11 April 2019

RJC:KV15-166

**Re: State Significant Development Application: SSD 7693
InterContinental Hotel and Transport House
Response to request for additional information**

SSD STAGE 1 - REV B ENVELOPE

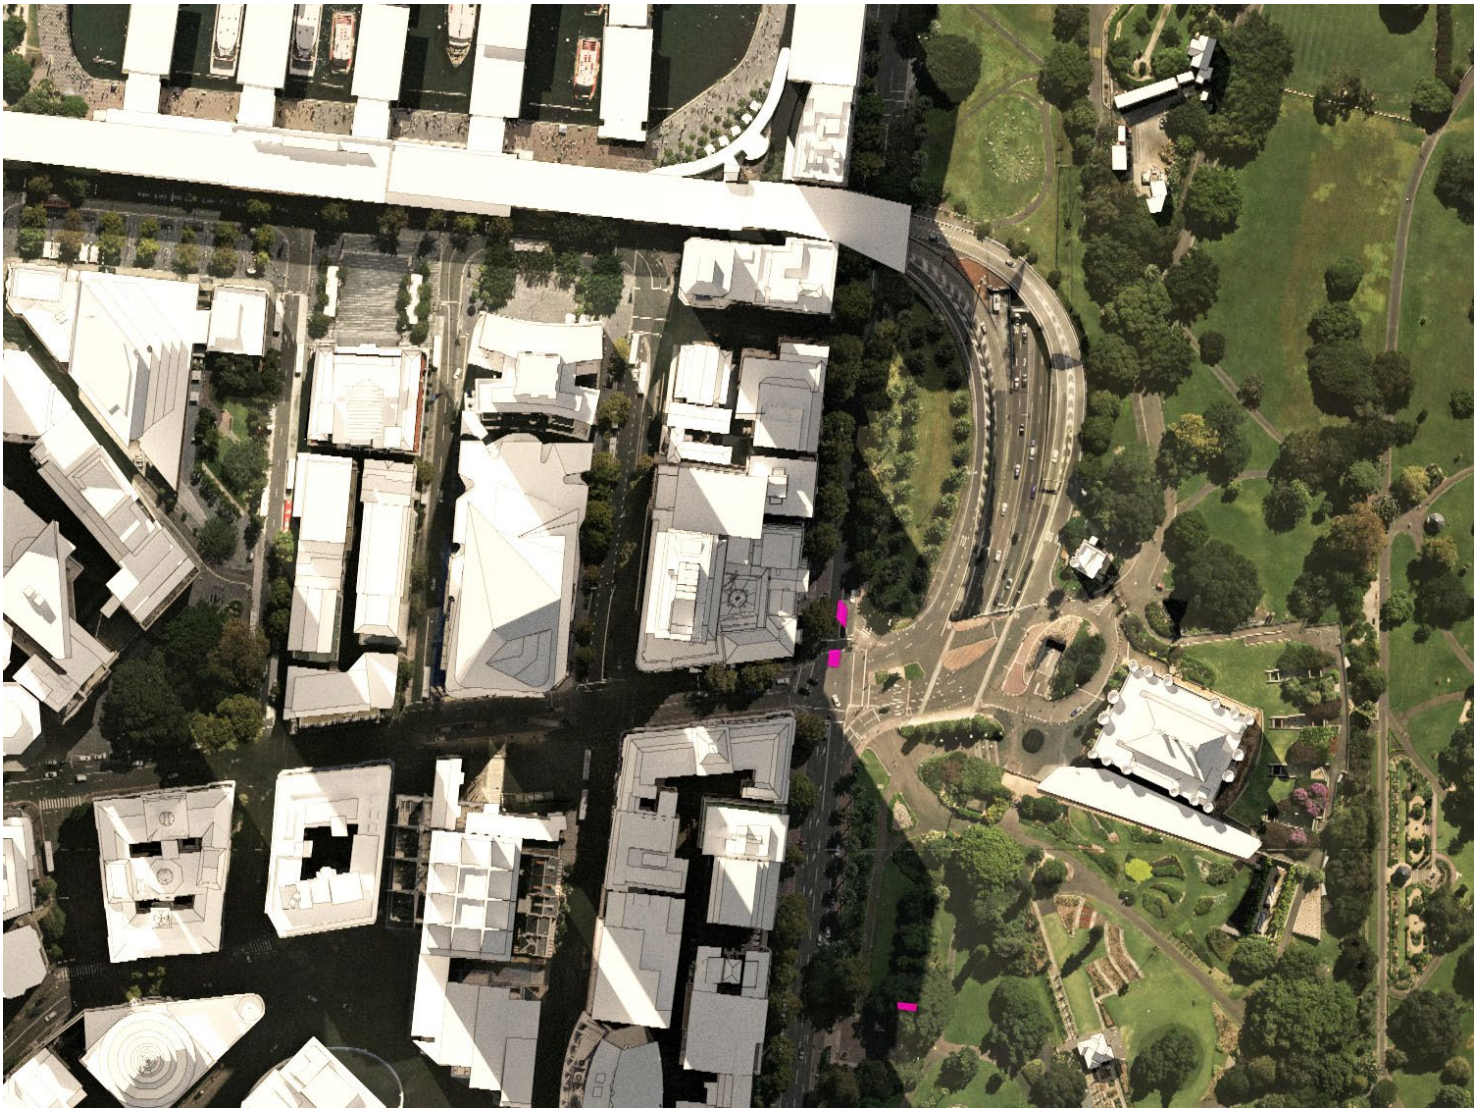
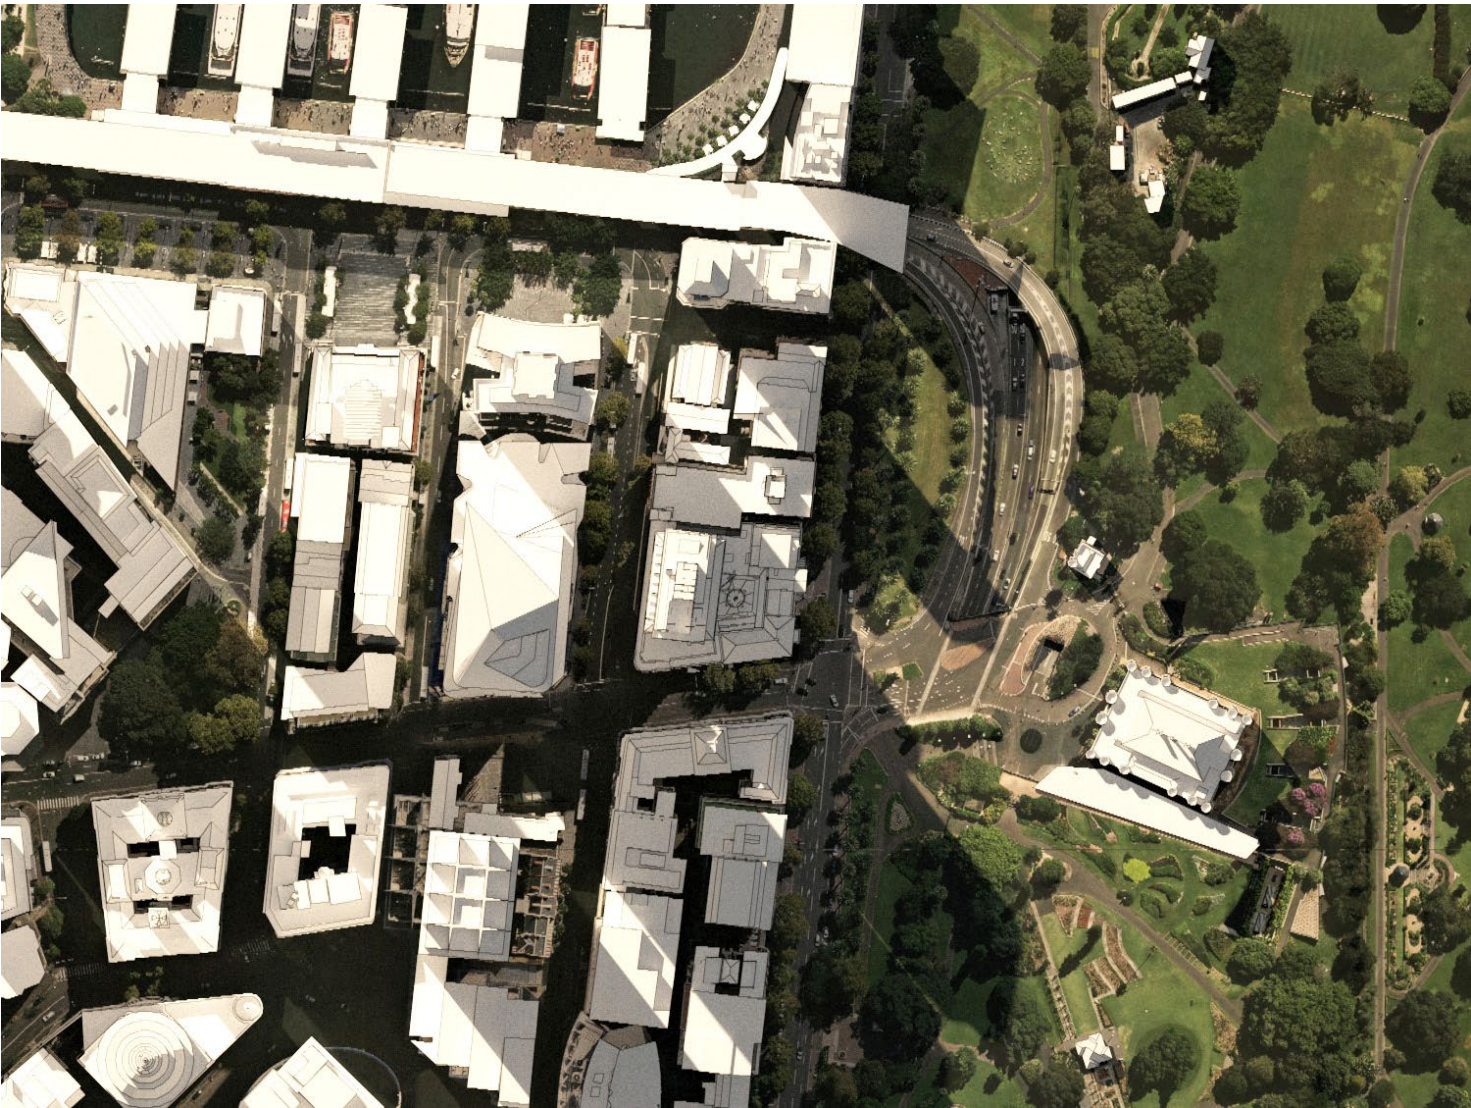
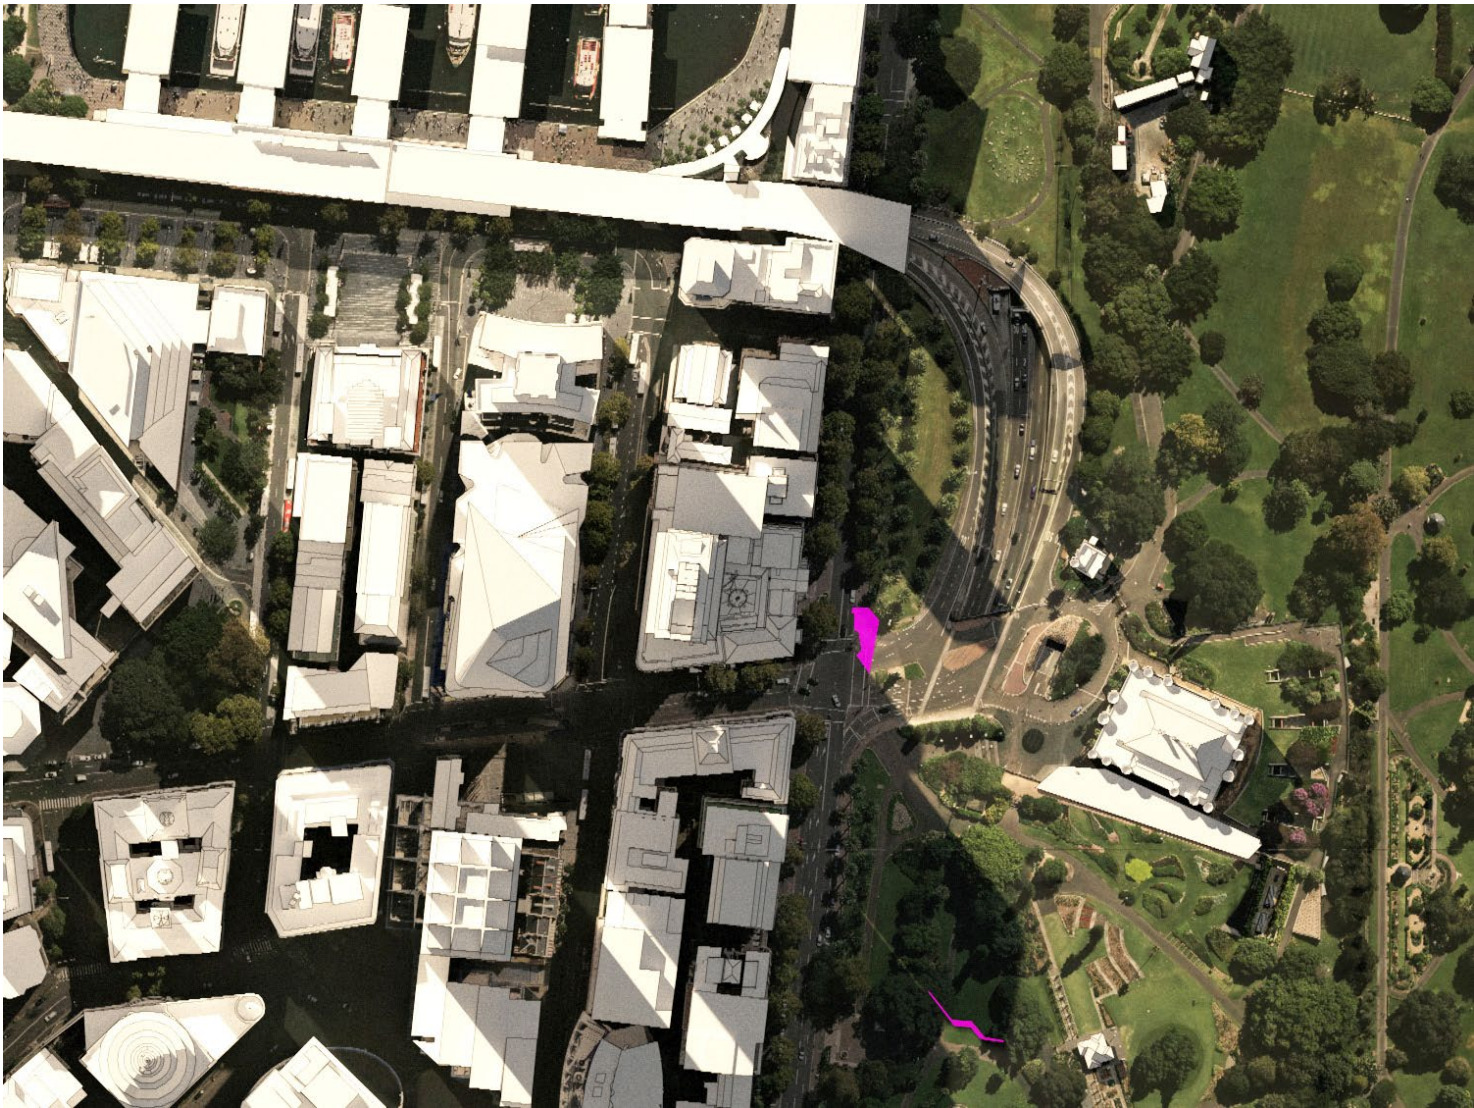
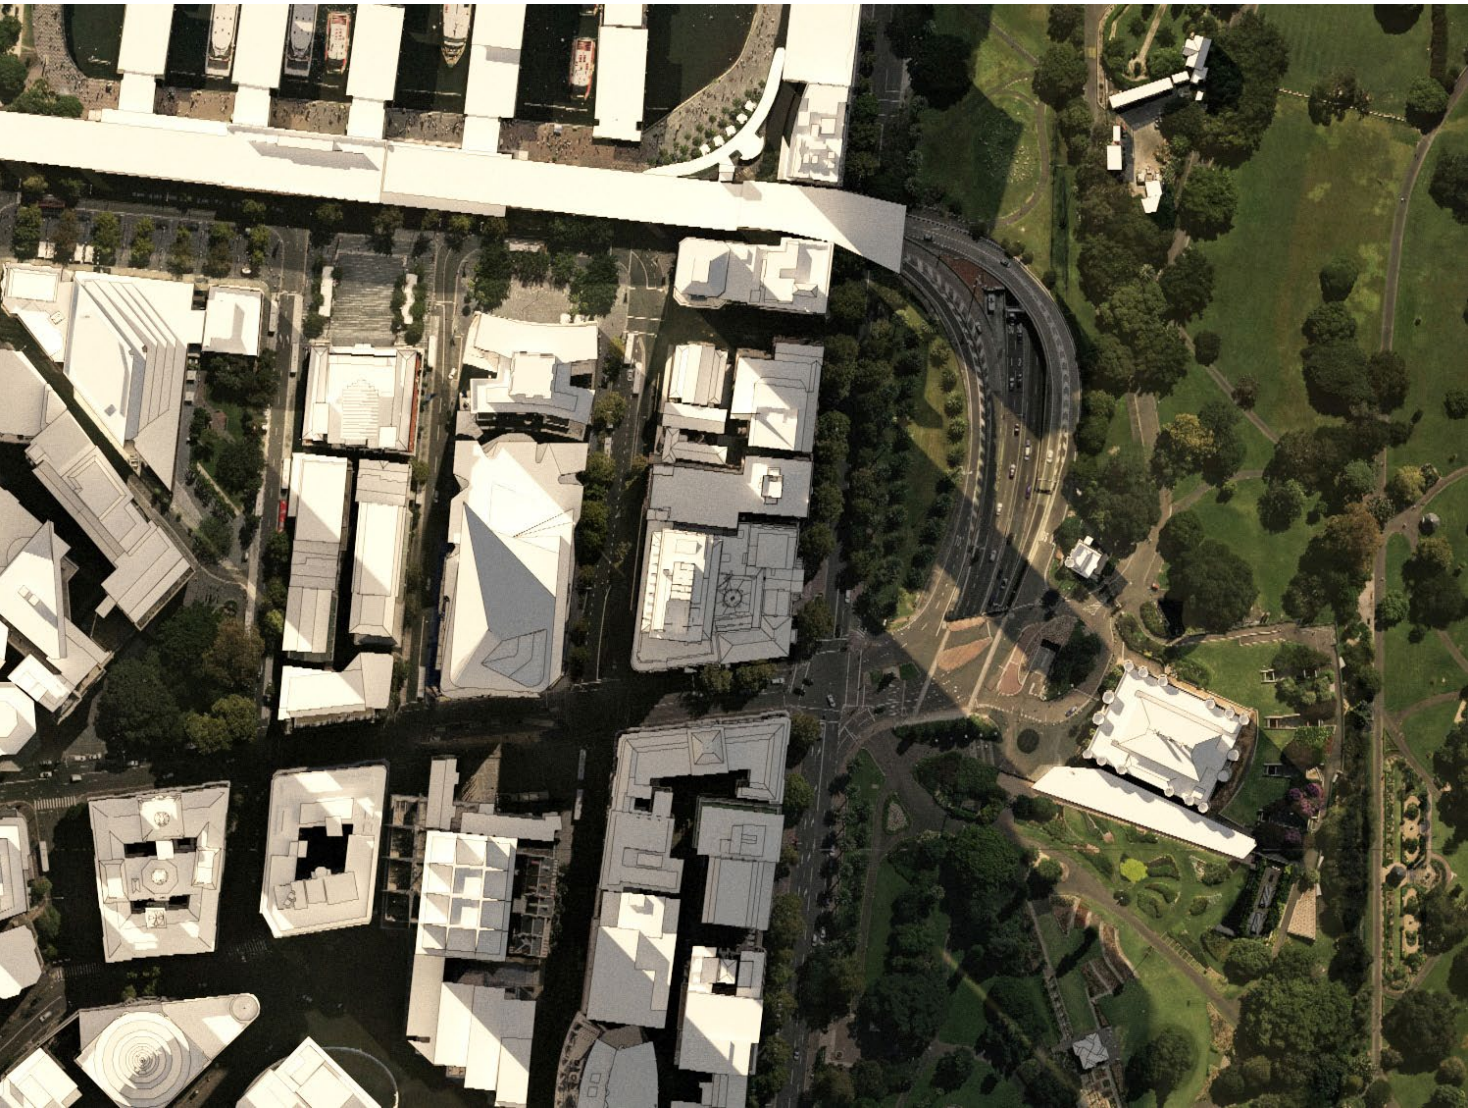
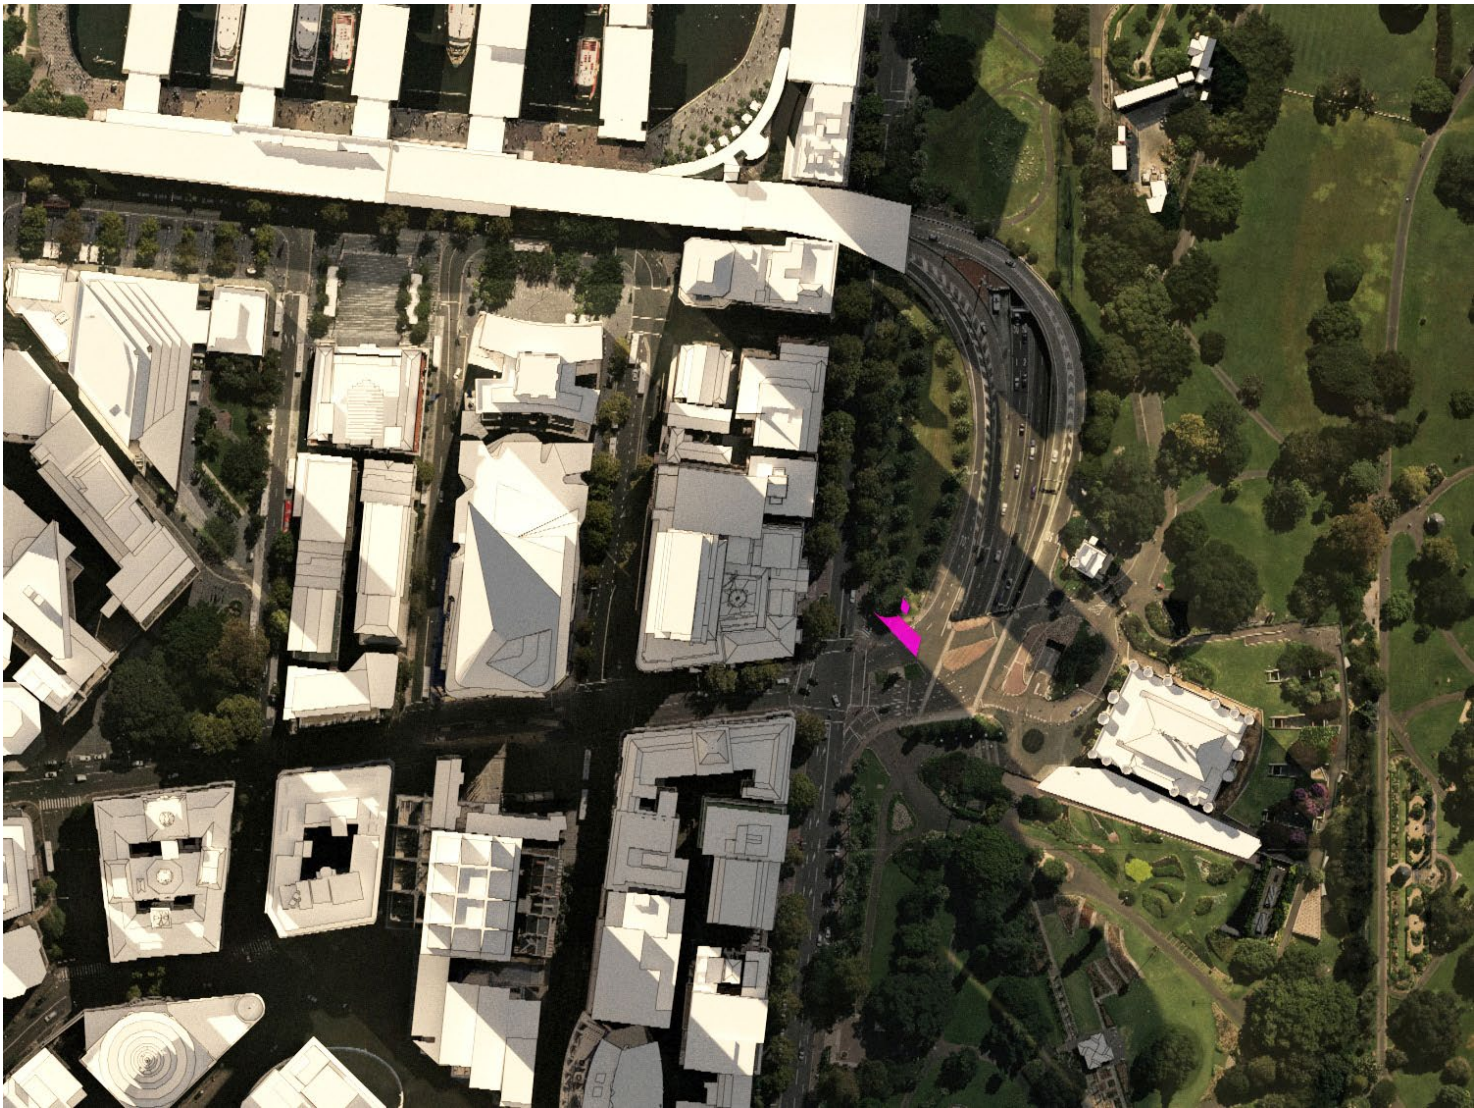
- (a) The shadow diagrams submitted are difficult to interpret. Revised shadow diagrams are to be submitted in a similar format to those prepared by Hassel Architects (example shown below). The shadow diagrams are to be overlayed with an aerial image and any additional overshadowing caused by the proposed building envelope when compared to existing development is to be shown in red.**

- (b) Shadow diagrams are to be provided in hourly intervals from 9am to 4pm for the winter solstice. In addition, shadow diagrams for half hour intervals are to be provided from 2pm-4pm on winter solstice in order to clearly understand the overshadowing impact to the Royal Botanic Gardens. The extent (i.e. duration and area in m²) of overshadowing to the Royal Botanic Gardens (RBG) shall also be quantified.**

Response: Shadow diagrams have been prepared consistent with the previous presentation format as requested by the Department – see Shadow Presentation Items A, B and C provided in **Attachment 1**.

Response: Shadow diagrams have been provided for the requested intervals 9am to 4pm at the Winter Solstice – see Items A (Hourly 9am to 2pm) and B (Hourly and half-hourly 2pm to 4pm).
